Item No. **Report of the Head of Planning, Sport and Green Spaces**

Address 2 BRIDGWATER ROAD RUISLIP

Development: Two storey side extension and installation of dormer to rear to allow for additional habitable roofspace

LBH Ref Nos: **18756/APP/2015/1527**

PROPOSED FIRST FLOOR PLAN

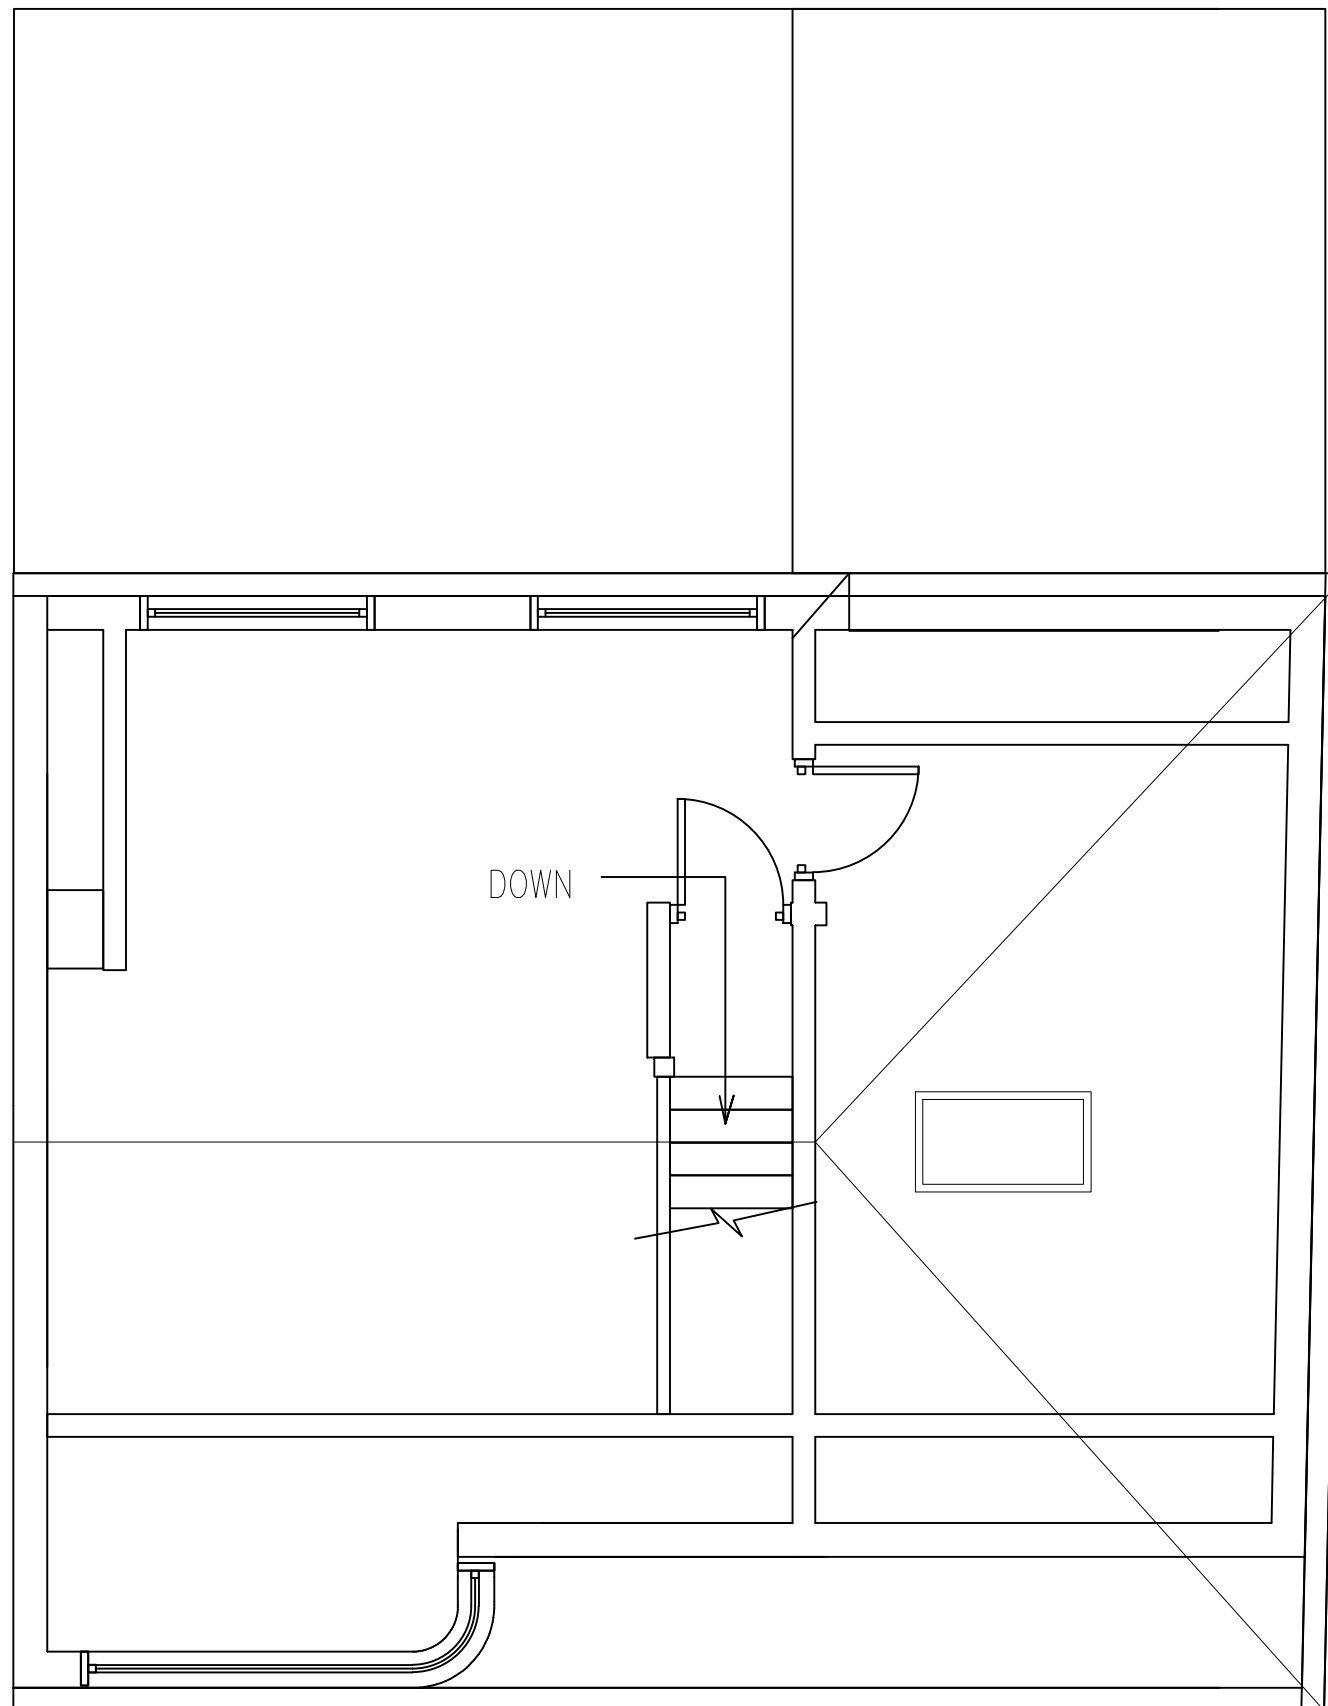
Part of the proposed two storey side extension will partly be built on top of the existing single storey rear extension, which will consist of a flat roof. However, a flat roof over a first floor extension is considered to be unacceptable, as stated in the SPD HDAS: Residential Extensions which states at Paragraph 6.6 that "two storey extensions to a house with a pitched roof should also have a pitched roof" and at Paragraph 6.7 which states that "flat roofed extensions will not generally be accepted." As such, the proposed rear element would fail to compliment the original dwelling and would be detrimental to the architectural composition of the existing building and the visual amenities of the street scene and the character and appearance of the wider area. This is particularly important given the location of the property in a visually prominent position, where the extension would be widely visible. The proposal is therefore contrary to Policy BE1 of the Hillingdon Local Plan: Part One - Strategic Policies (November 2012), Policies BE13, BE15 and

The proposed two storey side/rear extension, by virtue of its siting, size, scale and design, including the flat roof design, would be detrimental to the architectural composition of the existing building and the visual amenities of the street scene and the character and appearance of the wider area. The proposal is therefore contrary to Policy BE1 of the Hillingdon Local Plan: Part One - Strategic Policies (November 2012), Policies BE13, BE15 and BE19 of the Hillingdon Local Plan: Part Two - Saved UDP Policies (November 2012) and the adopted Supplementary Planning Documents HDAS: Residential Extensions.

PROPOSED 2nd/LOFT PLAN

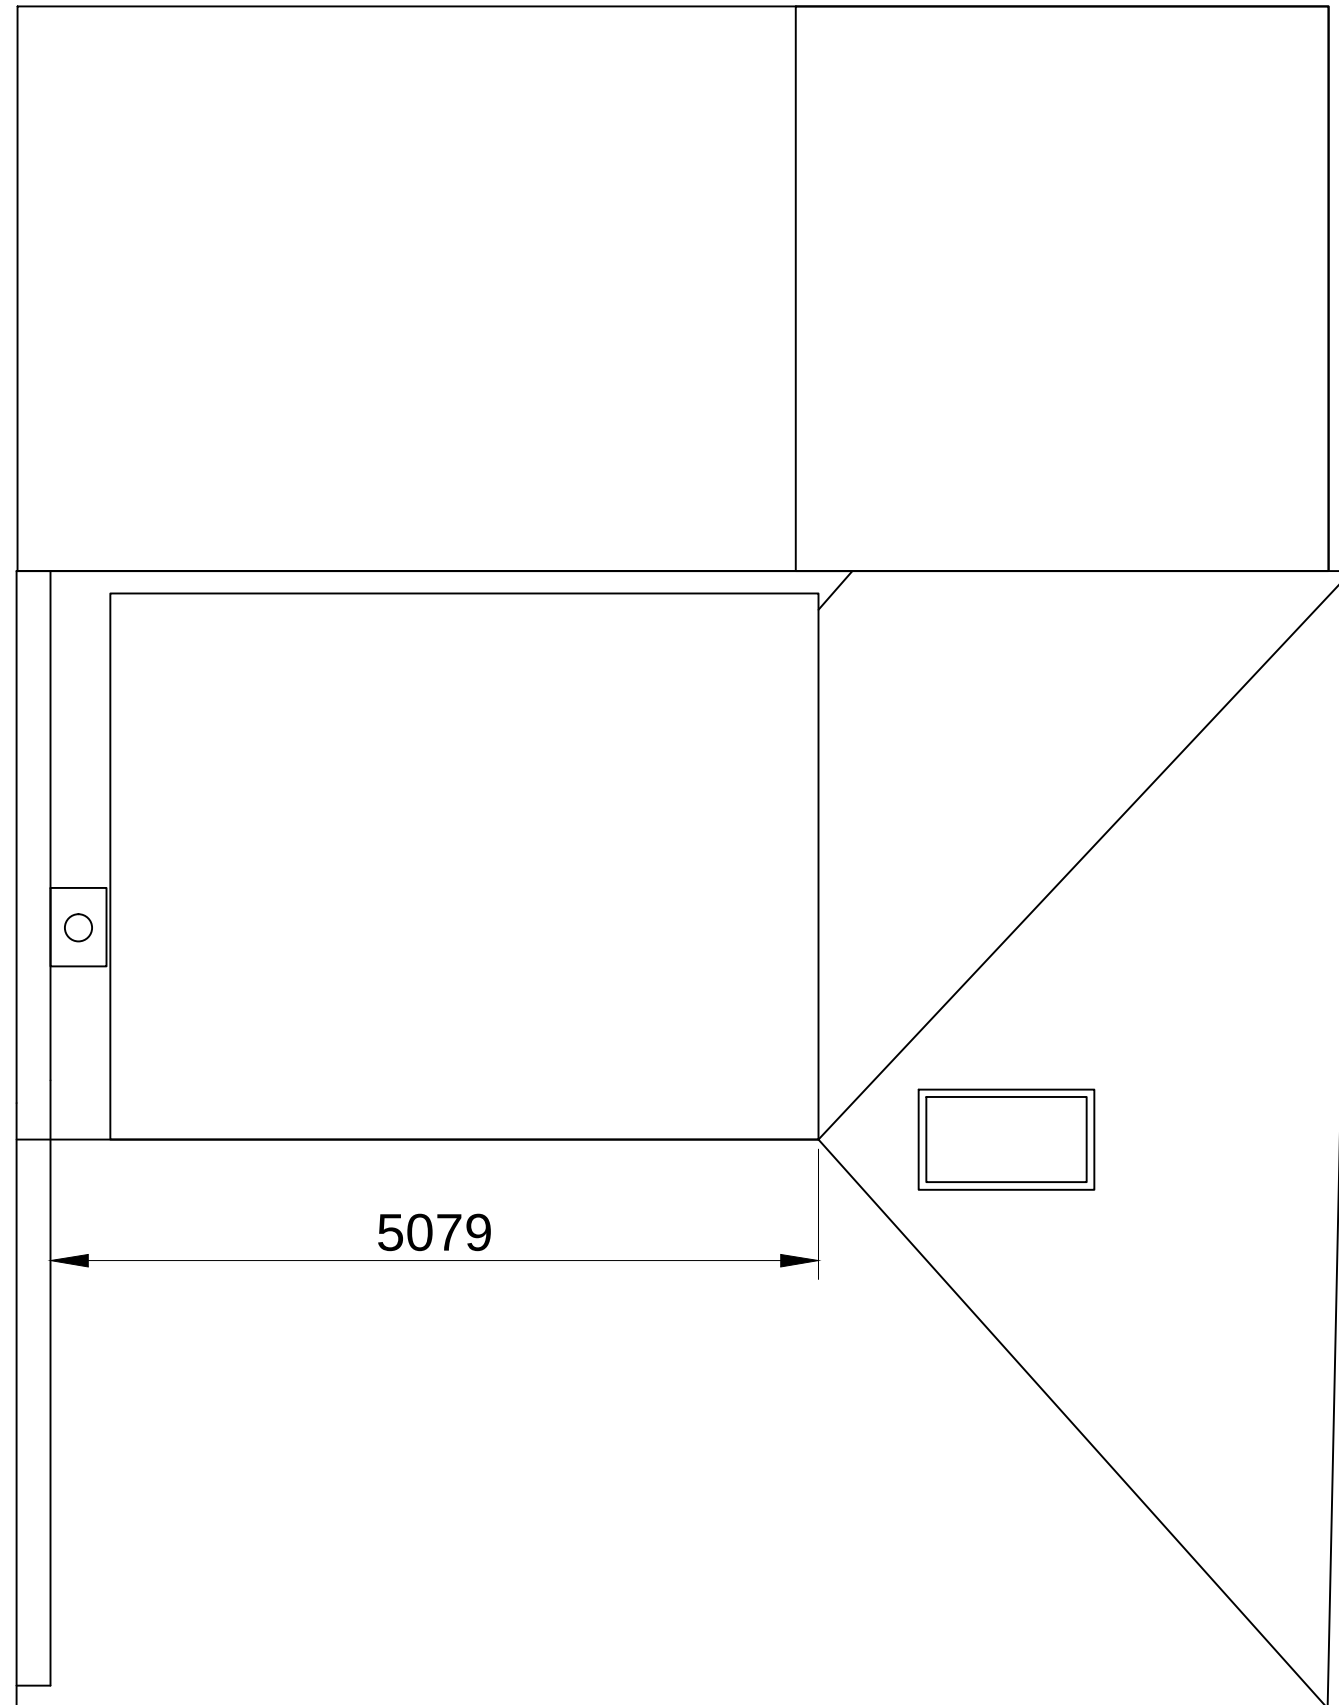
The proposed rear dormer will be located in the centre of the roof face and will be set down from the ridge of the roof by 0.30m and above the eaves by 0.50m. The proposed dormer will be 0.40m from the side of the roof. The proposed dormer will have a depth of 2.64m a height of 1.88m and a width of 4.77m, and would be across the original and extended roof face of the property resulting in a dominant addition which would not be secondary to the roof within which it is set.

The roof alteration, by reason of the size, scale, bulk, and design of the rear dormer window would fail to harmonise with the architectural composition of the original dwelling and would be detrimental to the character, appearance and visual amenities of the street scene and the surrounding area. Therefore the proposal would be contrary to Policy BE1 of the Hillingdon Local Plan: Part One - Strategic Policies (November 2012), Policies BE13, BE15 and BE19 of the Hillingdon Local Plan: Part Two - Unitary Development Plan Saved Policies (November 2012) and the adopted Supplementary Planning Document HDAS: Residential Extensions.
